RE: Resubmittal #2 of Site Plan-DFT_PR2019-002765_SP-2025-00003 | Comment Response Letter #2

The following memo provides responses to DFT staff comments for Target ABQ W Site Plan located at St. Joseph's Dr NW between Coors Blvd NW and Atrisco Dr NW on February 12th, 2024. Staff comments are in *italic* followed by the Applicant responses that are in **red and bold**.

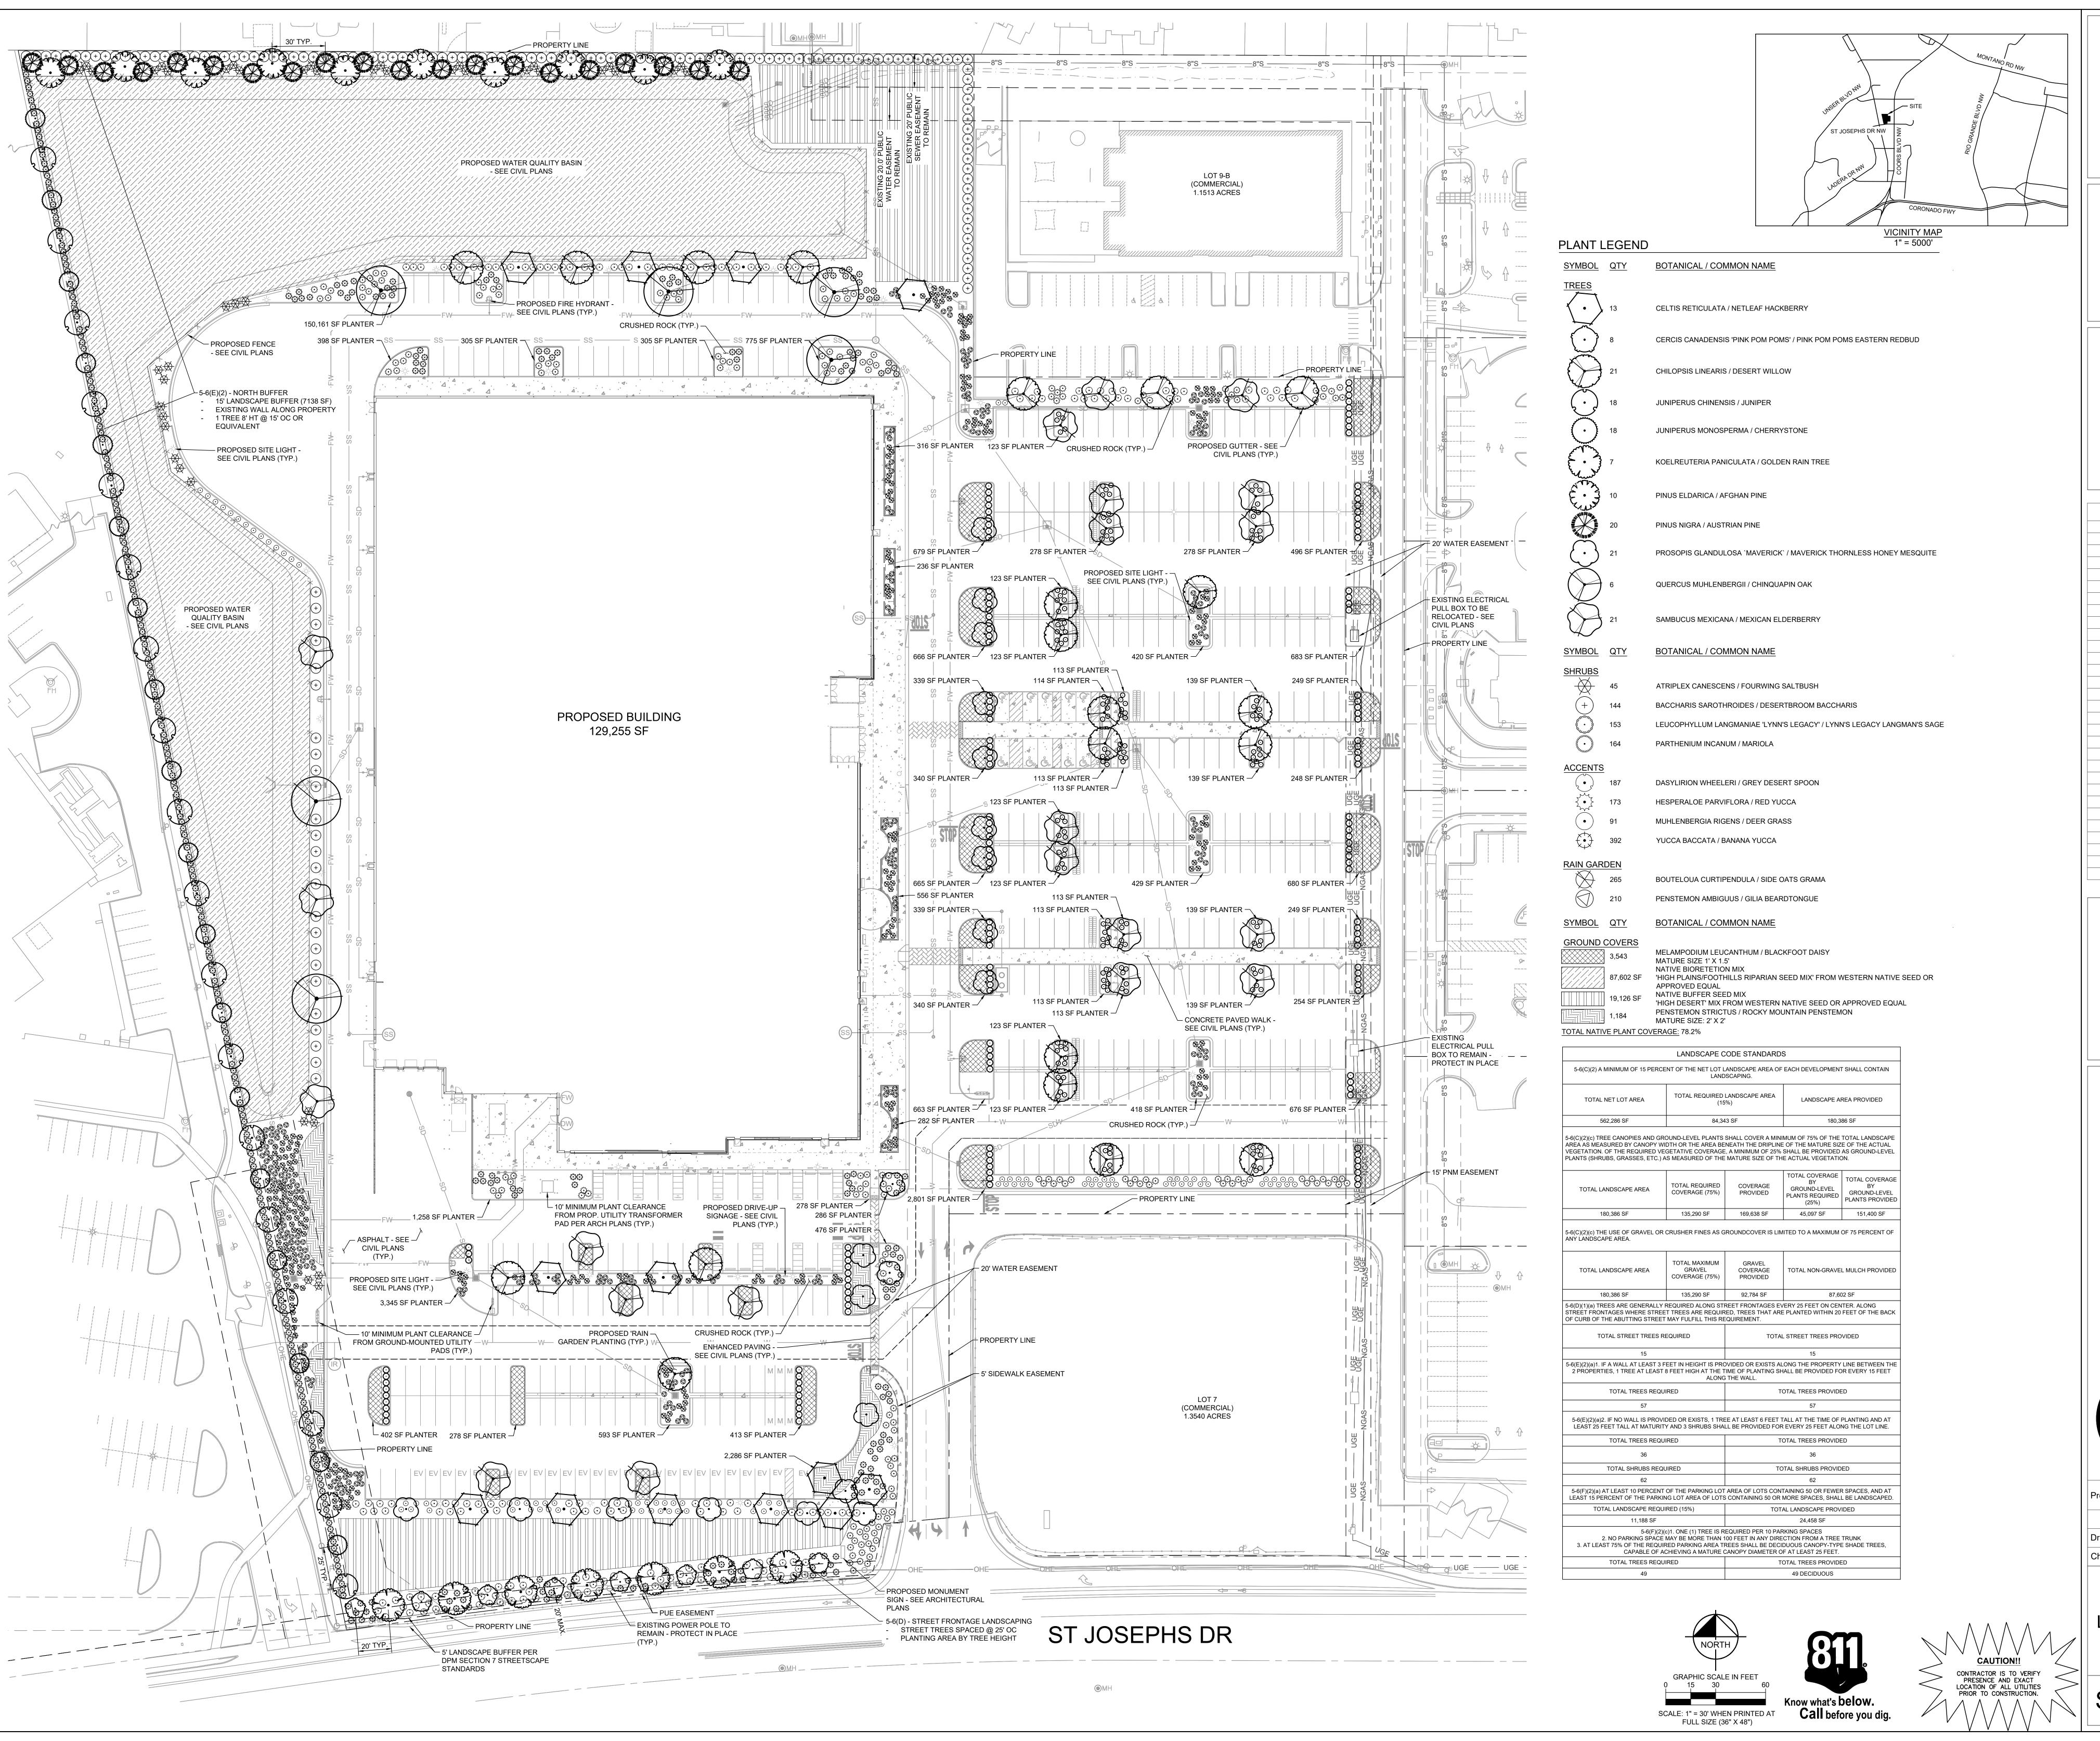
Clarify how the lighting plan meets Coors Pavillion plan and IDO sections 3-4-C & 5-8. Provide specific details related to 5-8. BUG ratings may be too high.

3. Show how lighting meets requirements of IDO 5-8, particularly along northern portion of property, which has more stringent lighting requirements due to adjacent to residential neighborhood.

Applicant Response: BUG ratings have been updated to conform with IDO Section 5-8(C)(3)(a) and do not exceed G2. The proposed lighting plan conforms with Coors Pavillion plan and IDO sections 3-4-c and 5-8.

Applicant Response: The lighting plan meets all requirements of IDO section 5-8. The foot candle level along the residential property is 0.0 fc.

LANDSCAPING

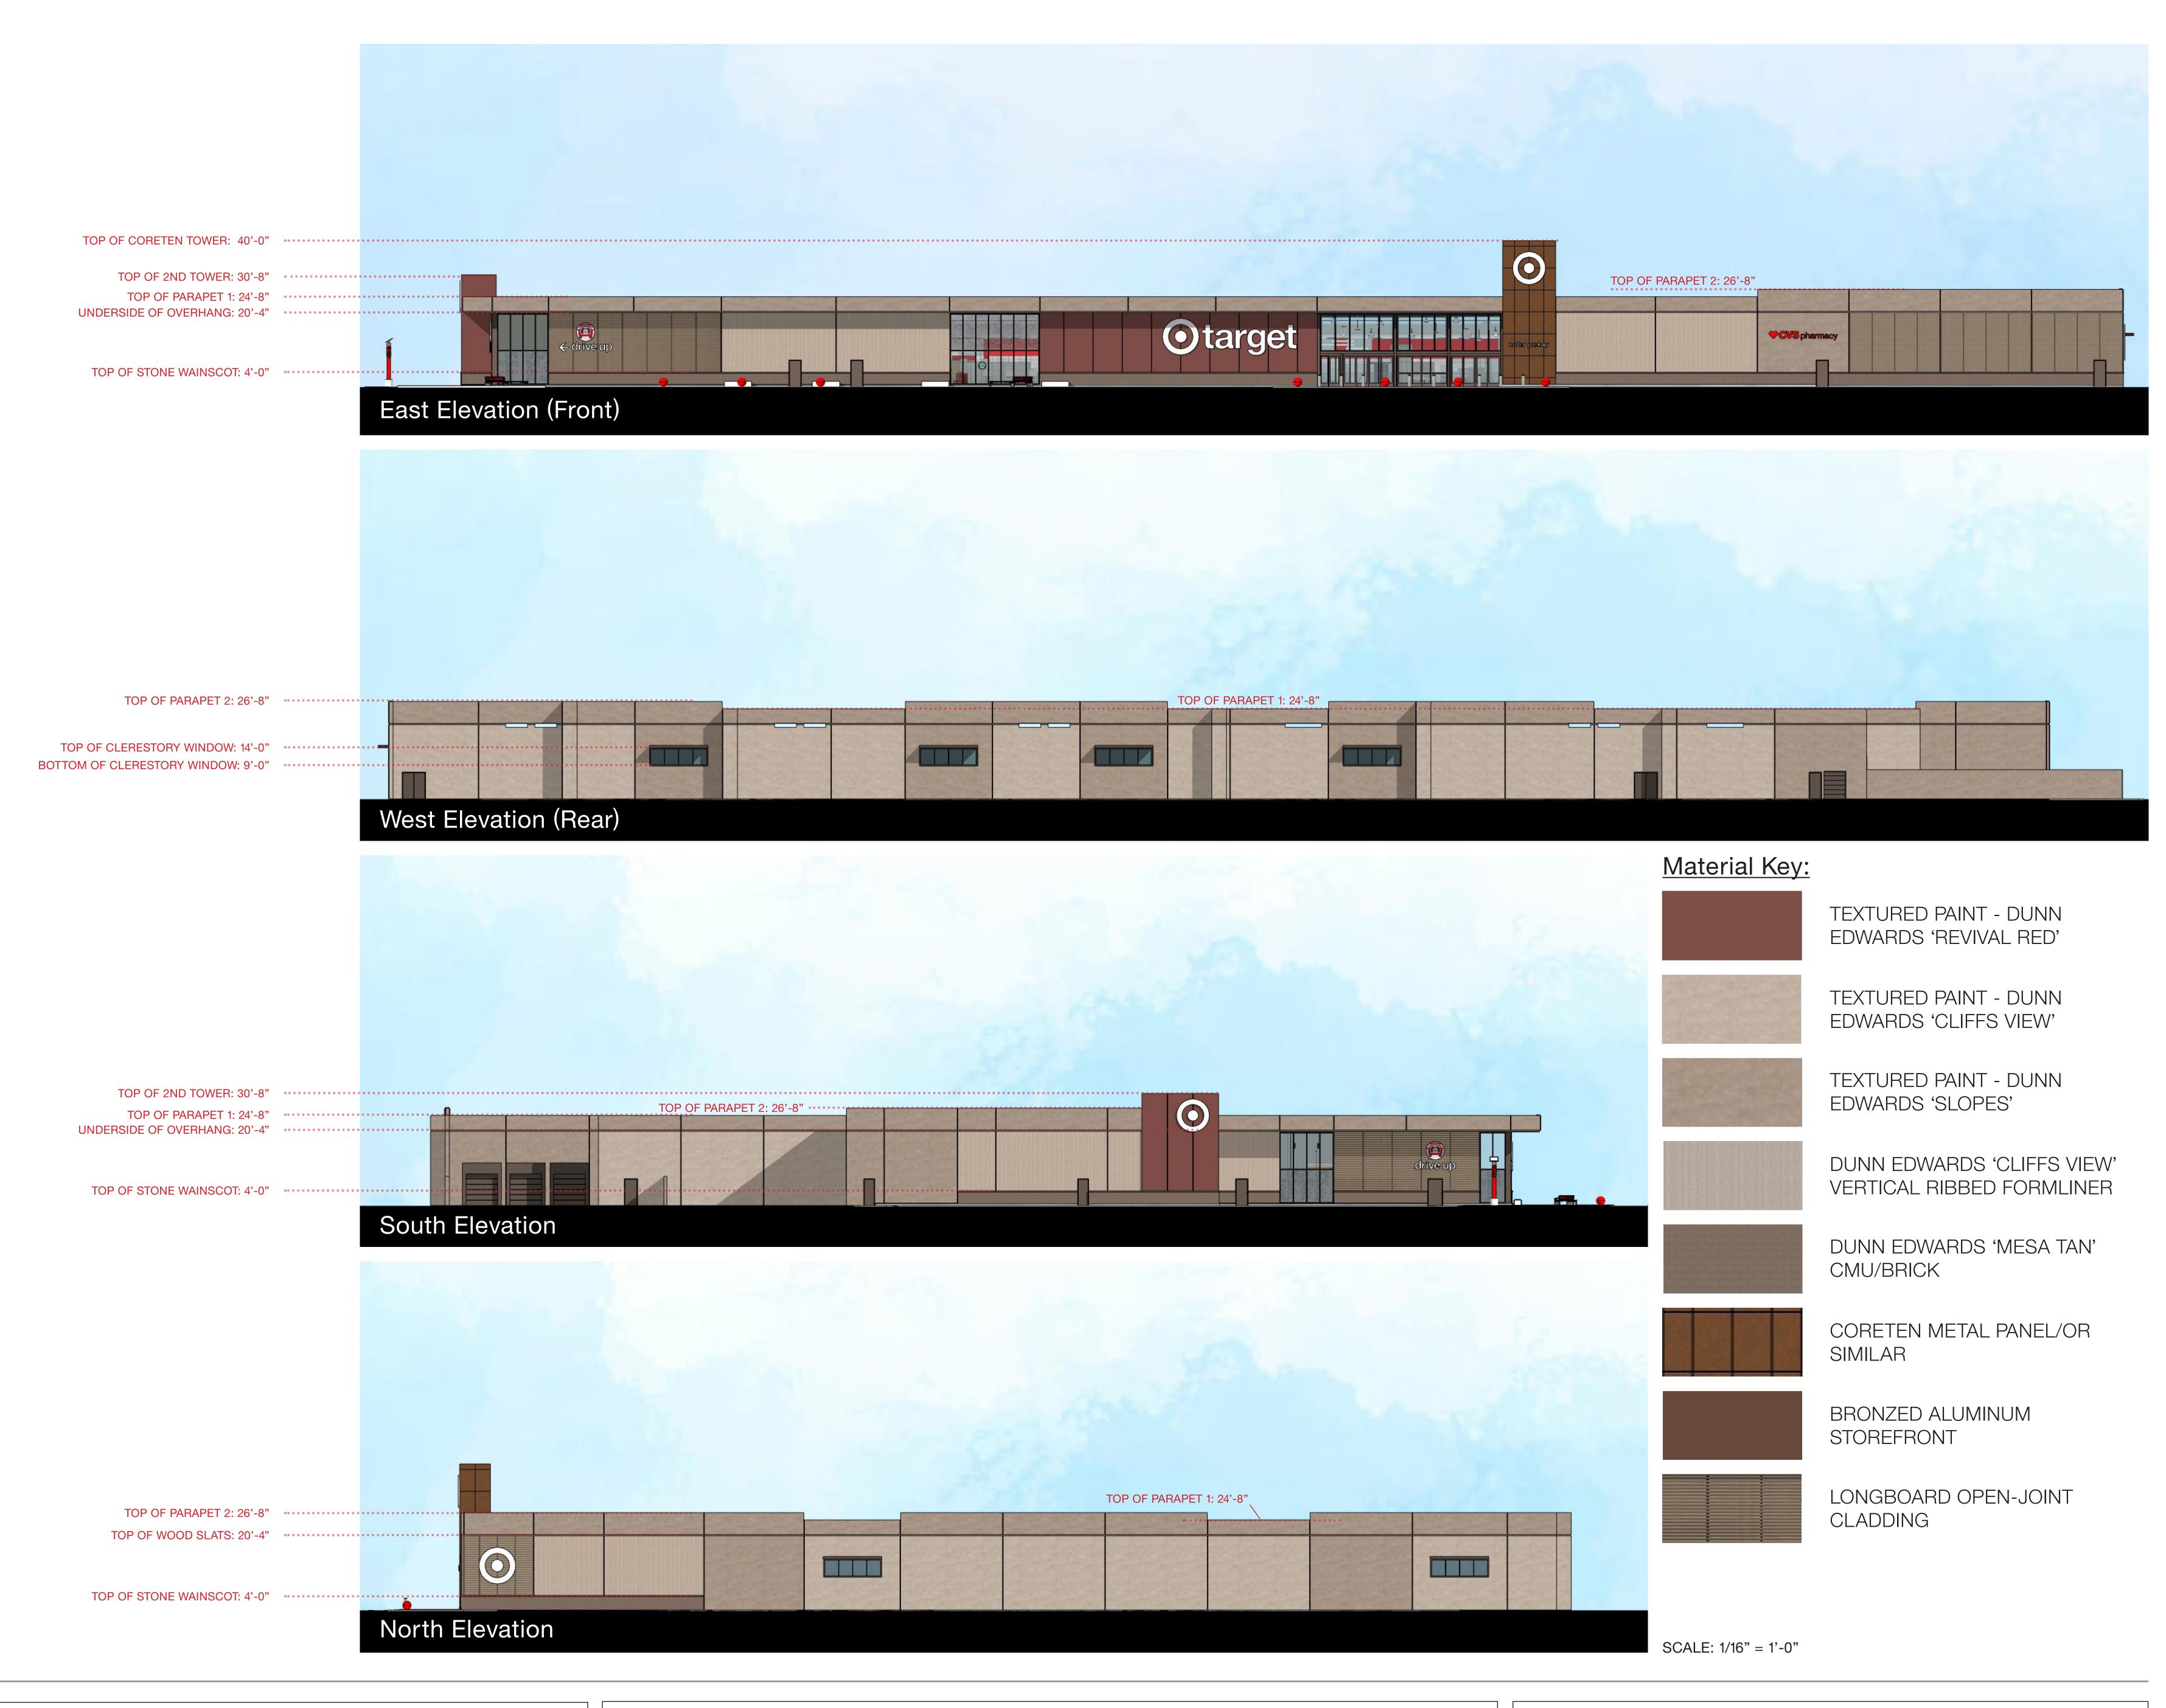
2. Fencing: Clarify location, type, and height of fencing throughout the property, and confirm it is in compliance with IDO 5-7 Walls and Fences. Note on St Joseph's Dr on Sheet 2A of the Landscaping plan says "existing fencing to remain" – however, we are not aware of any existing fencing along the street.

Applicant Response: The proposed fence will surround the stormwater pond, be chain link, and be a minimum of 42" high. The fence will be permitted separately during building permit and will adhere to IDO 5-7. The note on 2A was removed.
